**From:** Planning  
**Subject:** FW: WILD BOAR PARK LEAGRAM CHIPPING 03/2020/0579 and 0867 and 2021/0240

Chipping Parish Council would like to comment on the latest application 2021/0240 for the Wild Boar Park to erect nine holiday lodges with associated parking and sewage facility, as well as Discharge Condition 6 the Construction Management Plan.

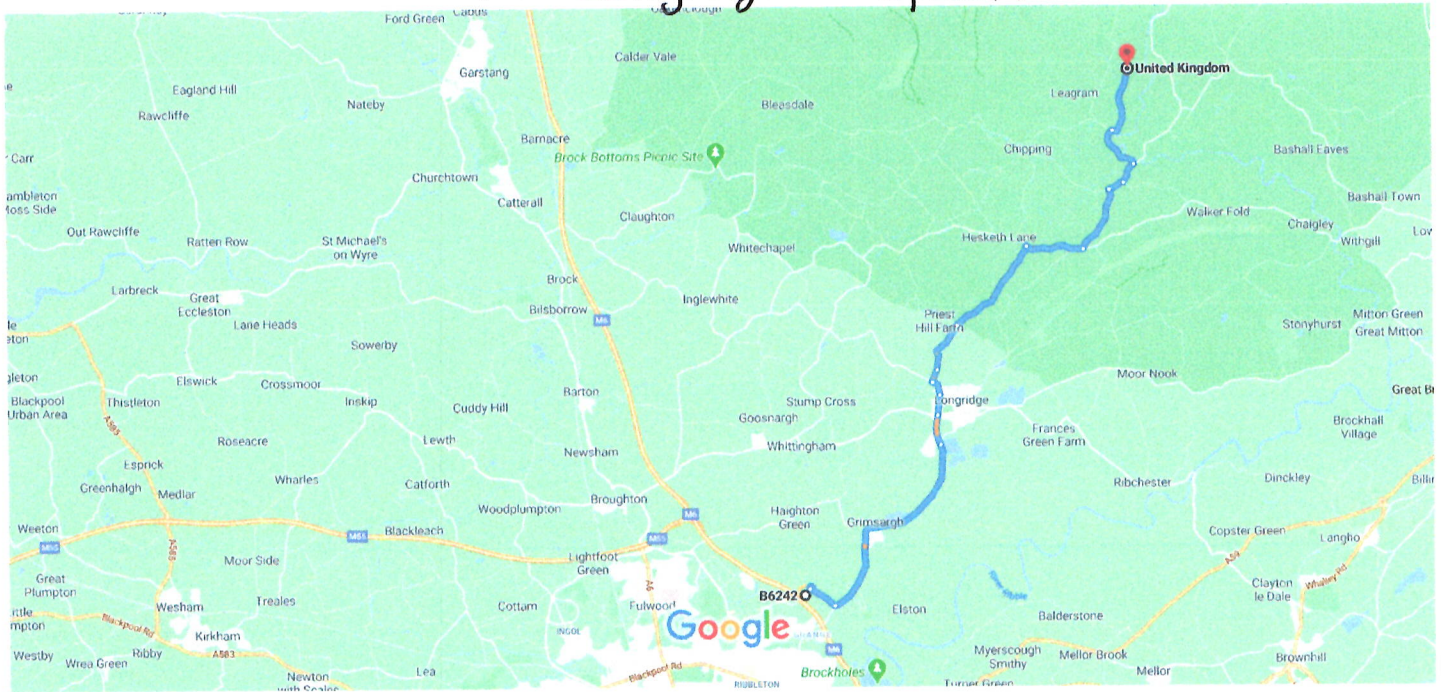
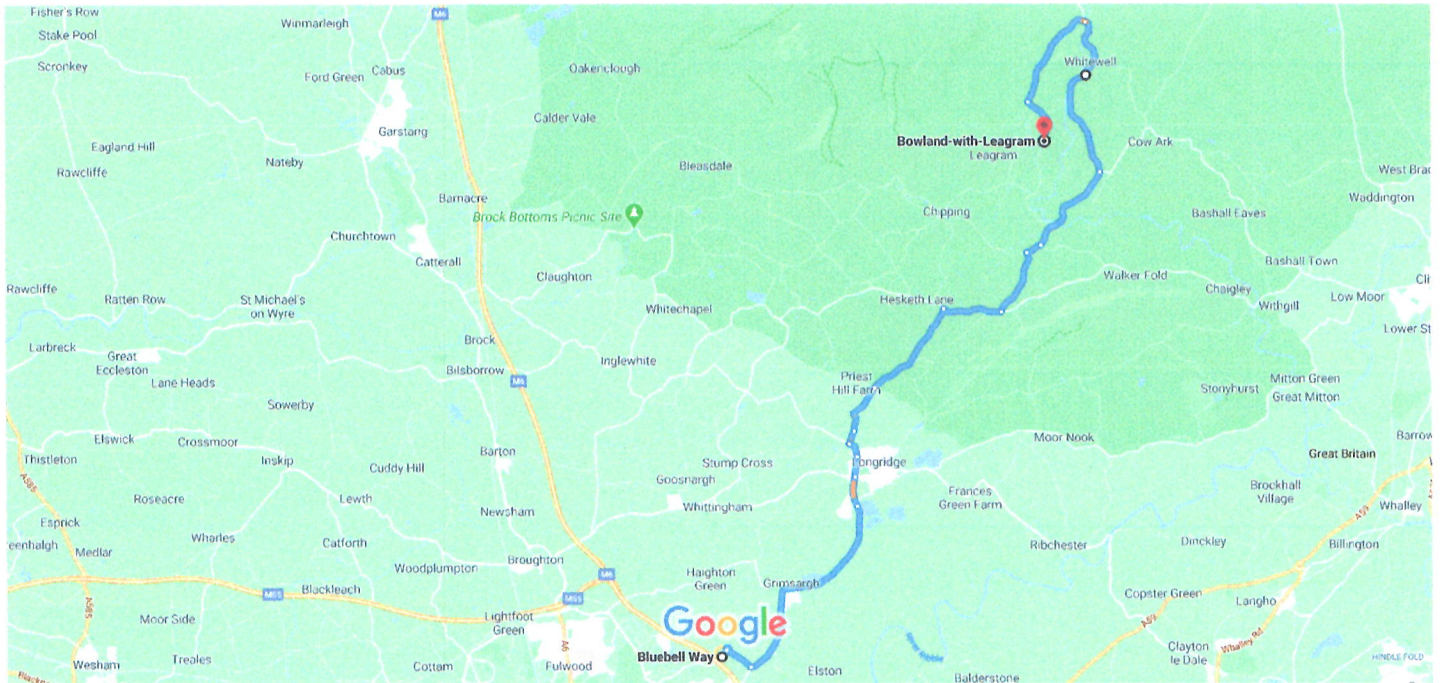
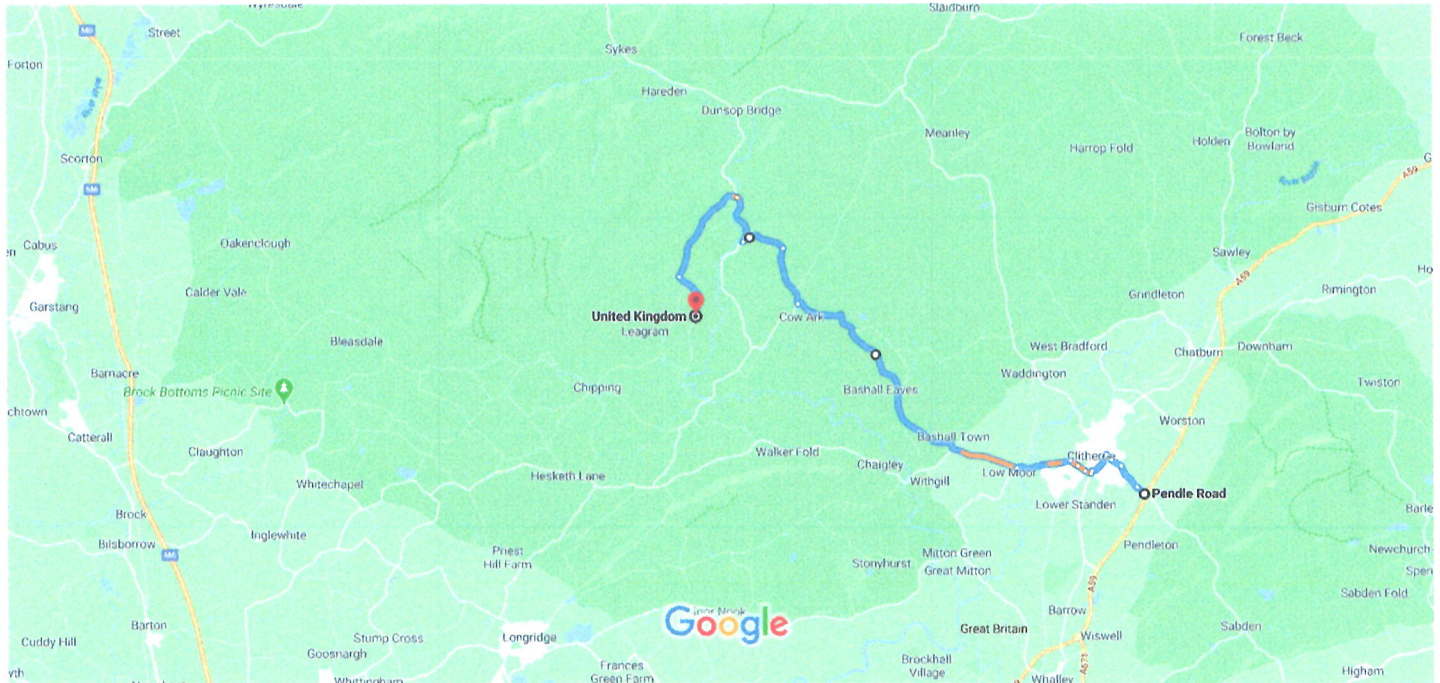
As with previous applications from the Wild Boar Park - we note that all construction of the lodges should happen at the site, but we have concerns as to the proposed routes by HGVs to the site. The maps provided by the applicant are poor, and as a Parish Council we would like to stress that it is not suitable to drive through the centre of our village via Windy Street onto Talbot Street (width - single lane, turning ability, as well as local residents parking, school children, walkers and cyclists). Should the application be approved, we would like a condition to be that the route through the centre of our village is not permitted.
